**Re: The Lamp Shop**  
**1310 Cuesta Abajo CT NE**  
**30-Day Temporary Certificate of Occupancy**  
**Transportation Development Final Inspection**  
Engineer's Stamp dated 6-30-20 (D16-D002J)  
Certification dated 3-14-22

Based upon the information provided in your submittal received 03-14-22, Transportation Development has no objection to a 30-day Temporary Certificate of Occupancy based. This letter serves as a "green tag" from Transportation Development for a 30-day Temporary Certificate of Occupancy to be issued by the Building and Safety Division.

A1 Bike Rack Detail - 3 Stall
SCALE: 1/2" = 1'-0"

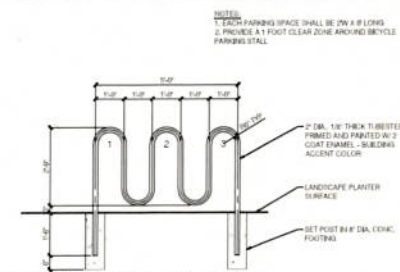
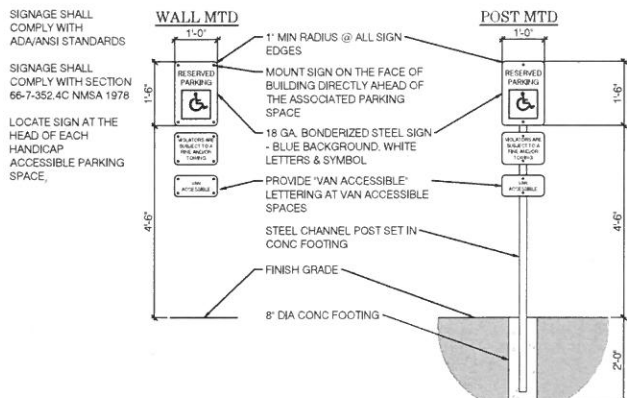
- Provide Bicycle Racks per the approved site plan.
- The ADA accessible parking sign must have the required language per 66-7-352.4C NMSA 1978 "**Violators Are Subject to a Fine and/or Towing.**" Please call out detail and location of signs.
